WEST SUSSEX COUNTY COUNCIL CONSULTATION

TO:	Arun District Council FAO: Anita Gardner
FROM:	WSCC - Highways Authority
DATE:	20 April 2022
LOCATION:	38/40 High Street Littlehampton
SUBJECT:	LU/82/22/PD Prior notification under Schedule 2, Part 3, Class G for the change of use of upper floors to 2 No flats.
DATE OF SITE VISIT:	n/a
RECOMMENDATION:	Advice
S106 CONTRIBUTION TOTAL:	n/a

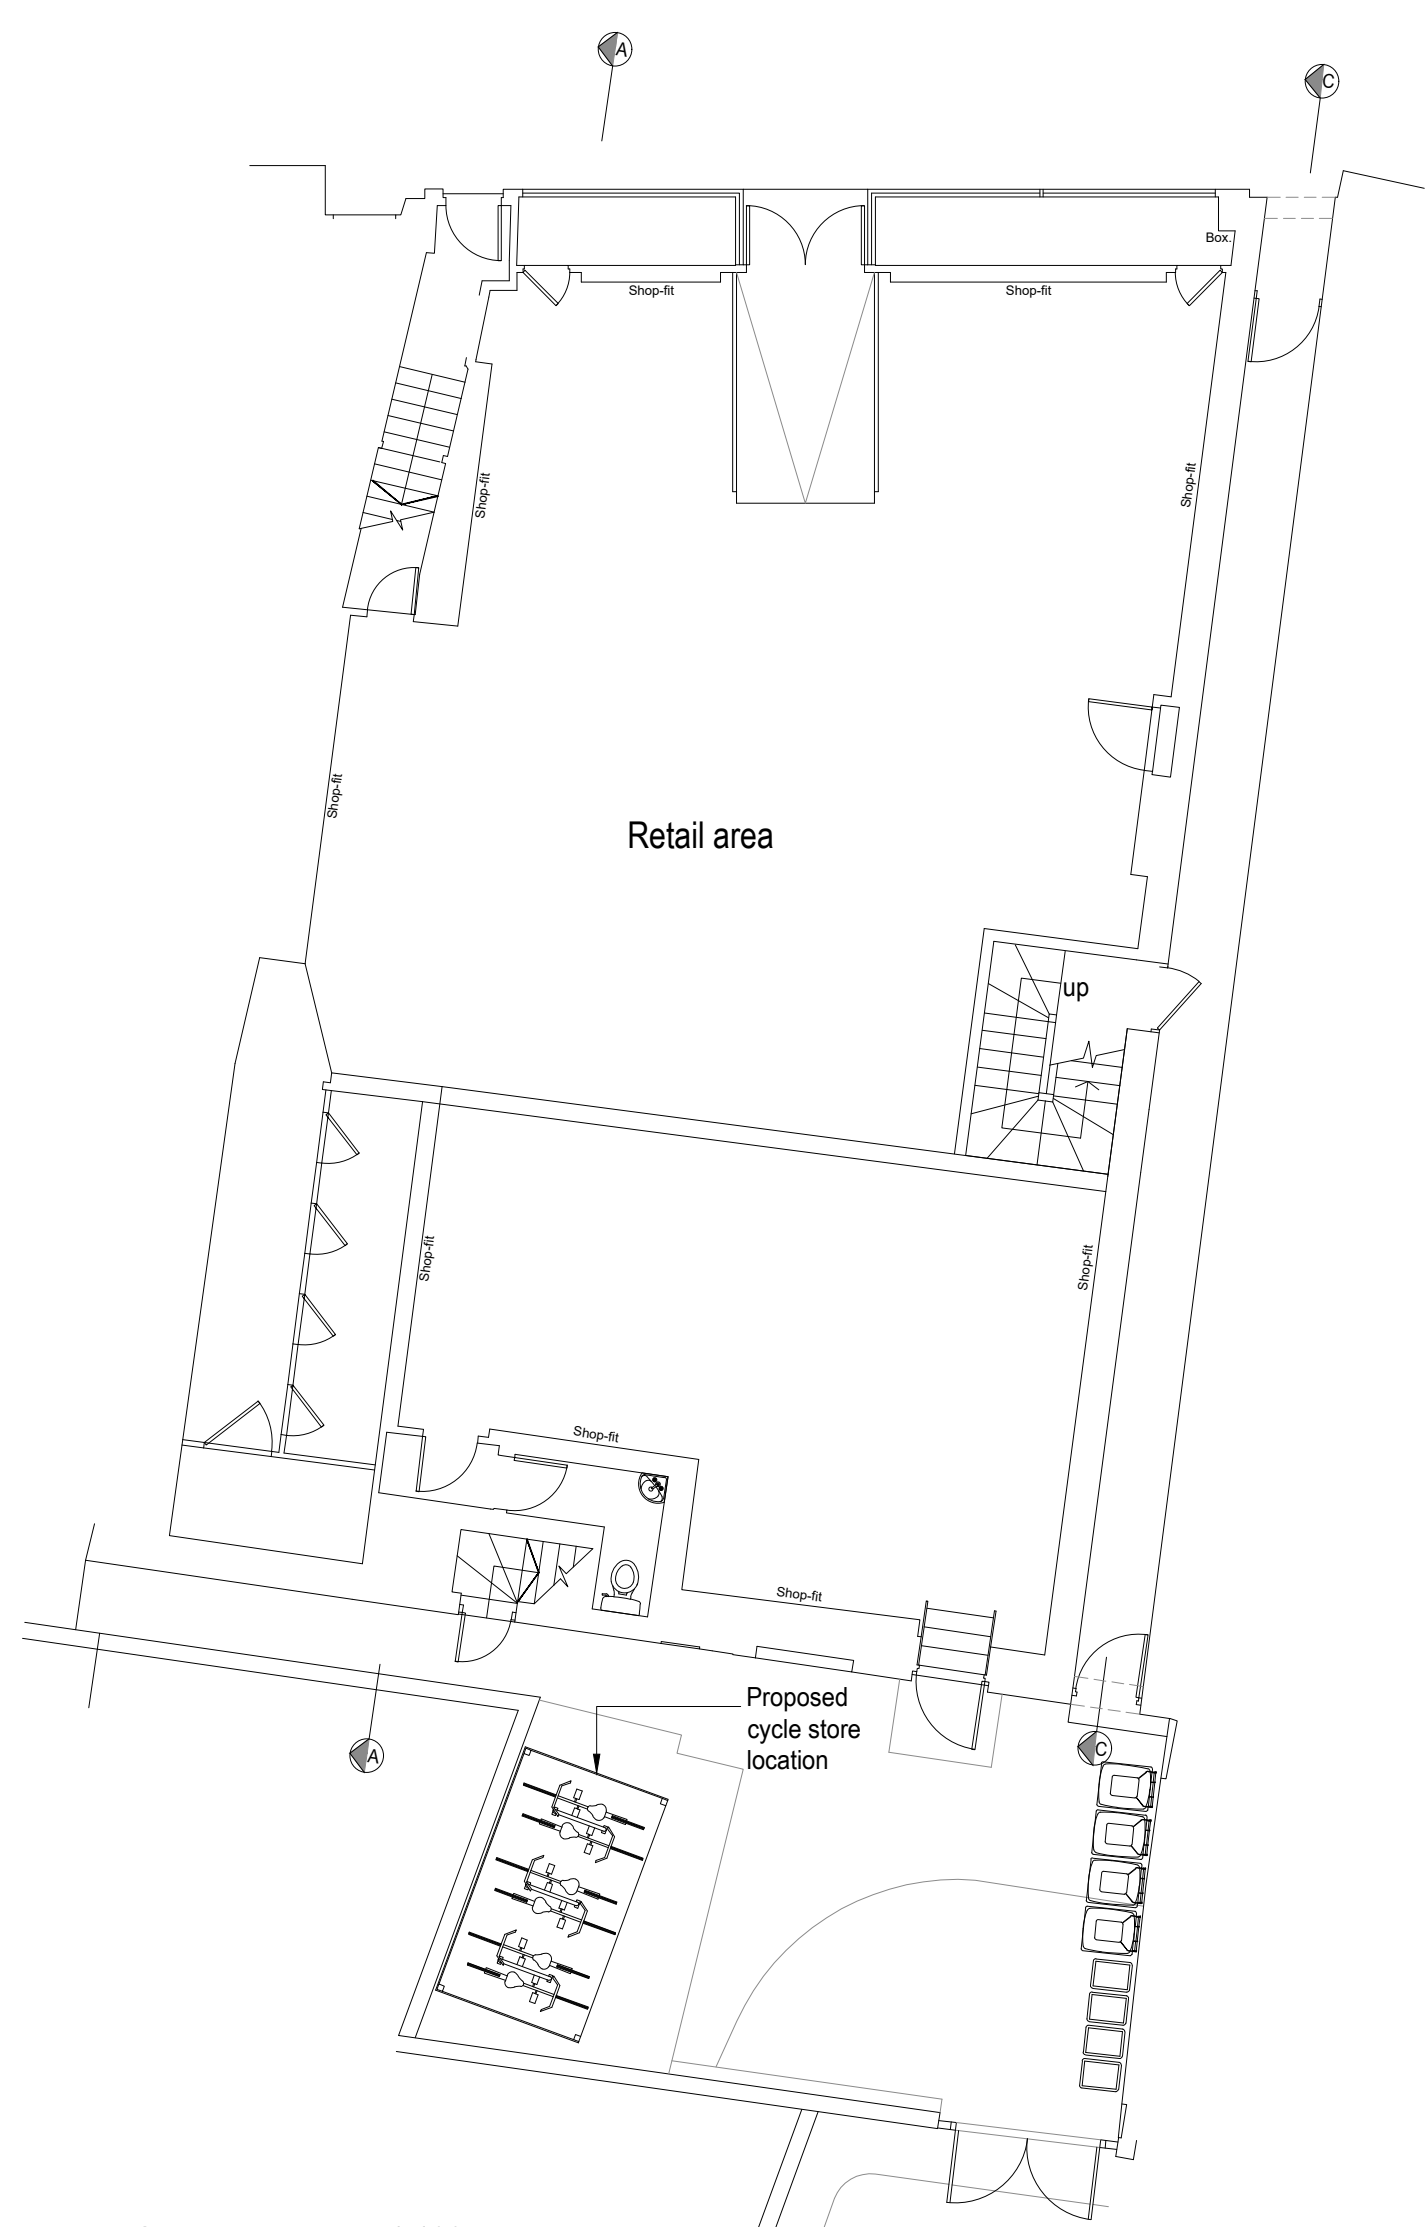
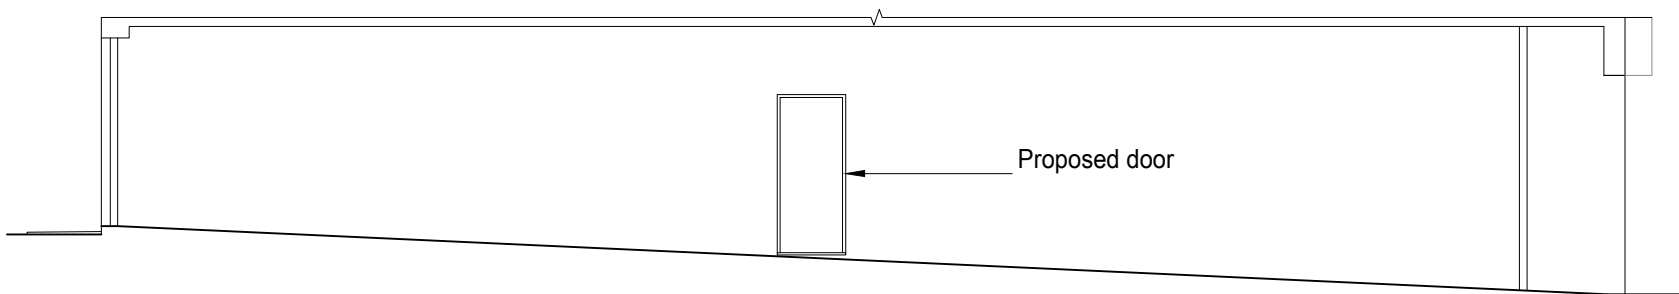
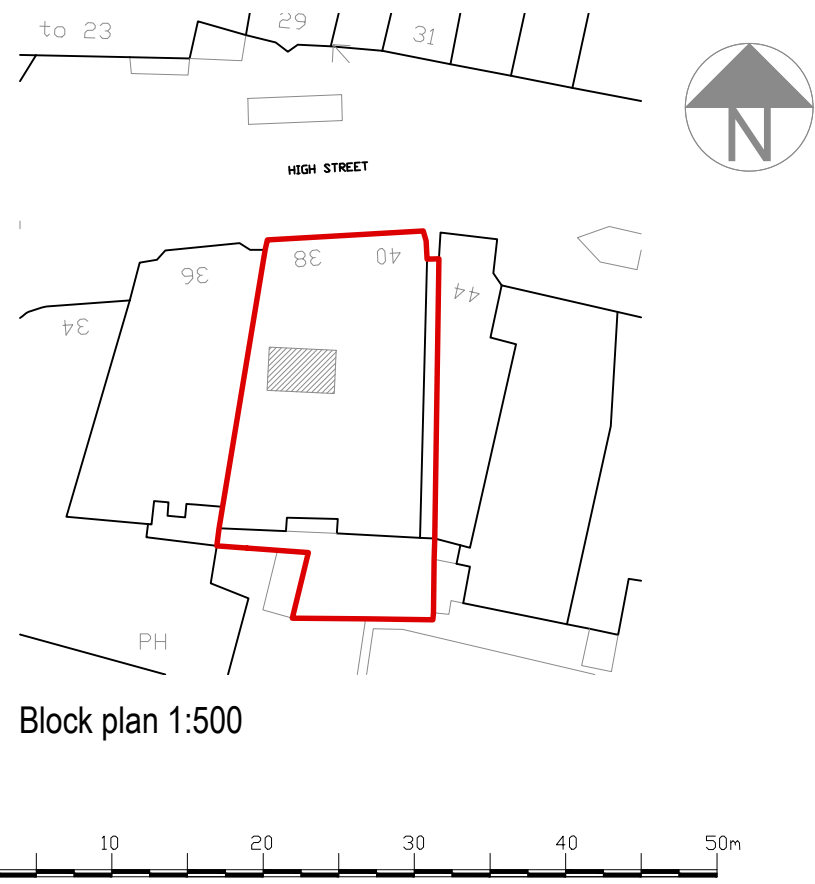
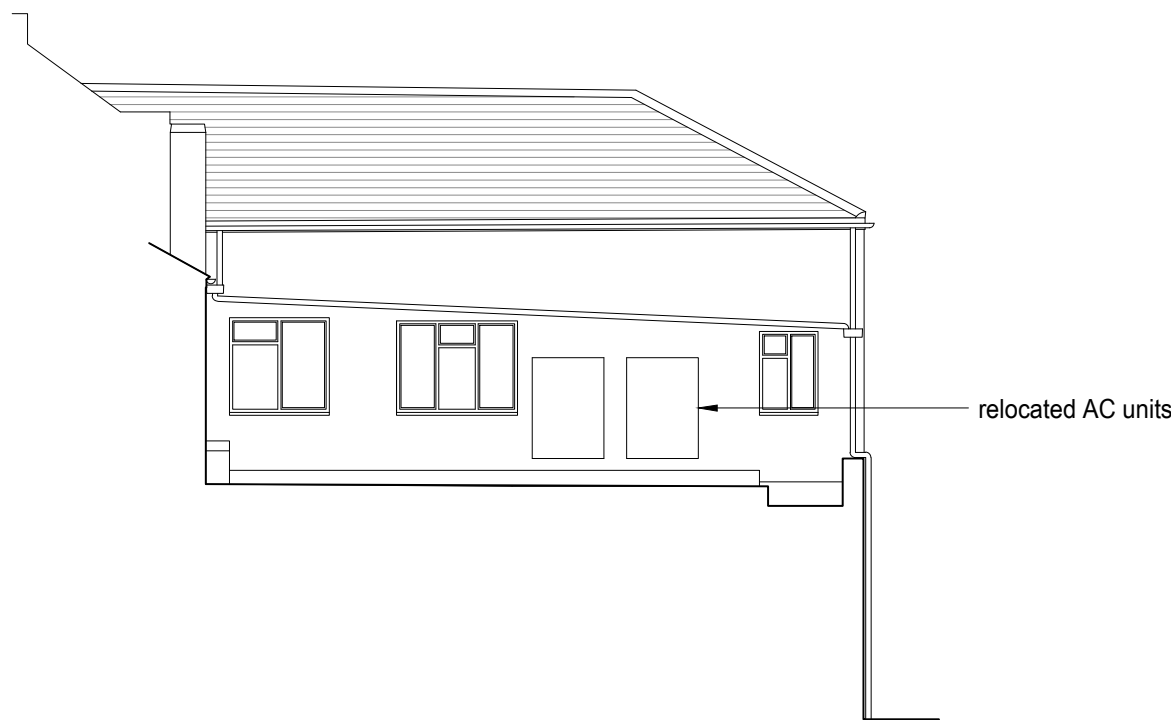
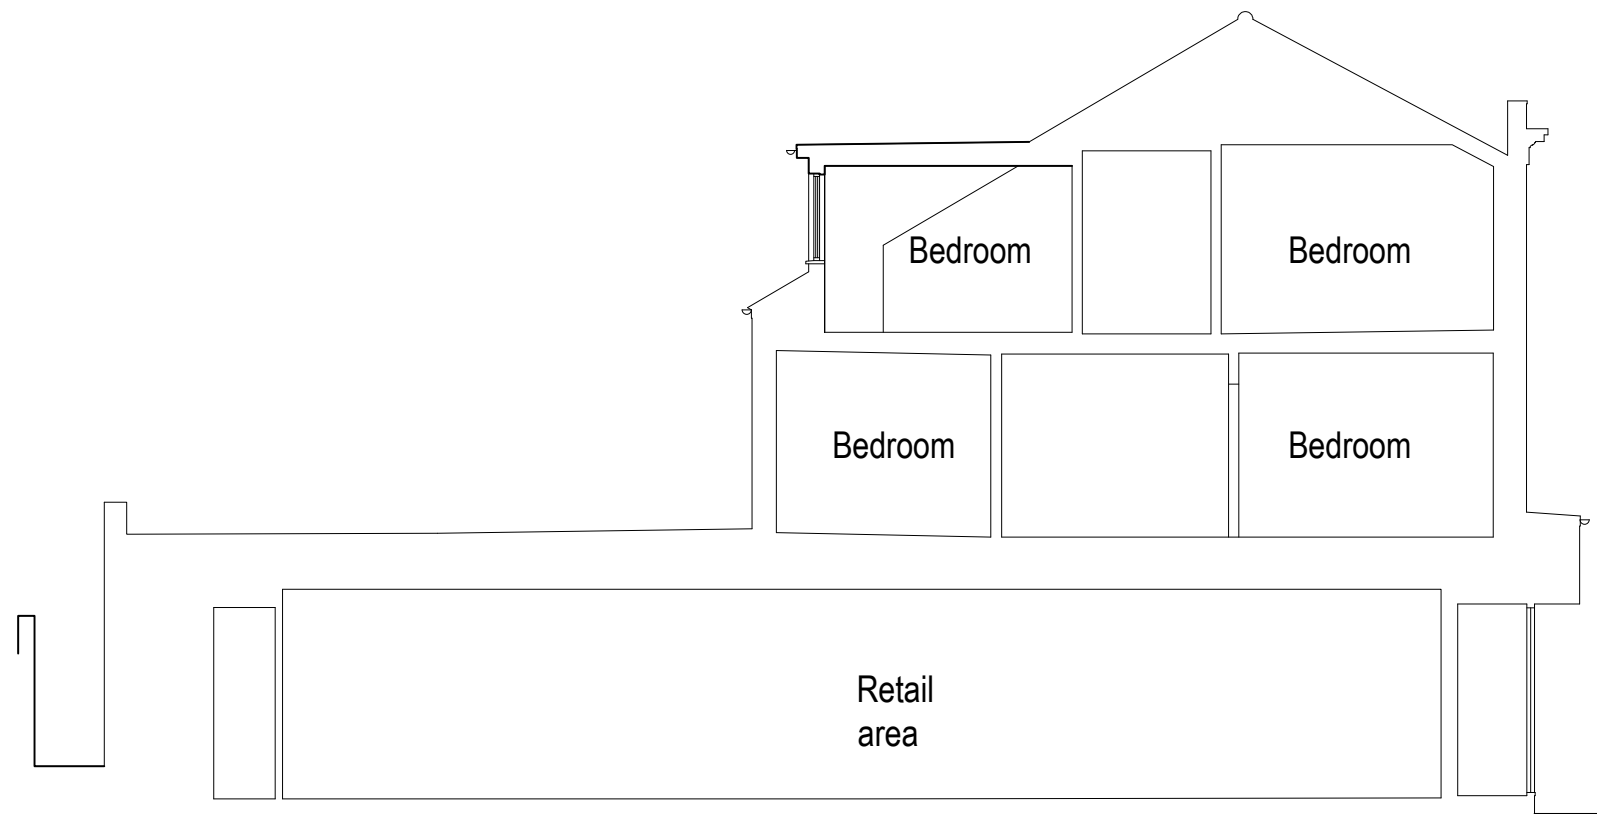
The application does not propose any parking provision or vehicular access to the dwellings. However the LHA appreciate the sustainable location of the site, situated within close proximity to local shops, bus services and a train station, and consider that there are viable options for sustainable modes of transport to reduce the reliance upon the private car. Under the WSCC parking demand calculator a minimum of 6 parking spaces could be provided for a development of this size and location. Whilst on-street car parking is limited in the immediate vicinity there are comprehensive parking restrictions prohibiting vehicles from parking in places that would be detriment to highway safety. We would not consider that highway safety would be detrimentally affected through the proposed nil car parking provision. The LPA may wish to consider the potential impacts of this proposal on on-street parking from an amenity point of view. The LHA anticipate that the level of traffic generated by the proposed dwelling would be of a similar nature to the potential of the existing use.

If the Local Planning Authority is minded to approve the application, they may wish to condition cycle parking as demonstrated on the proposed plans.
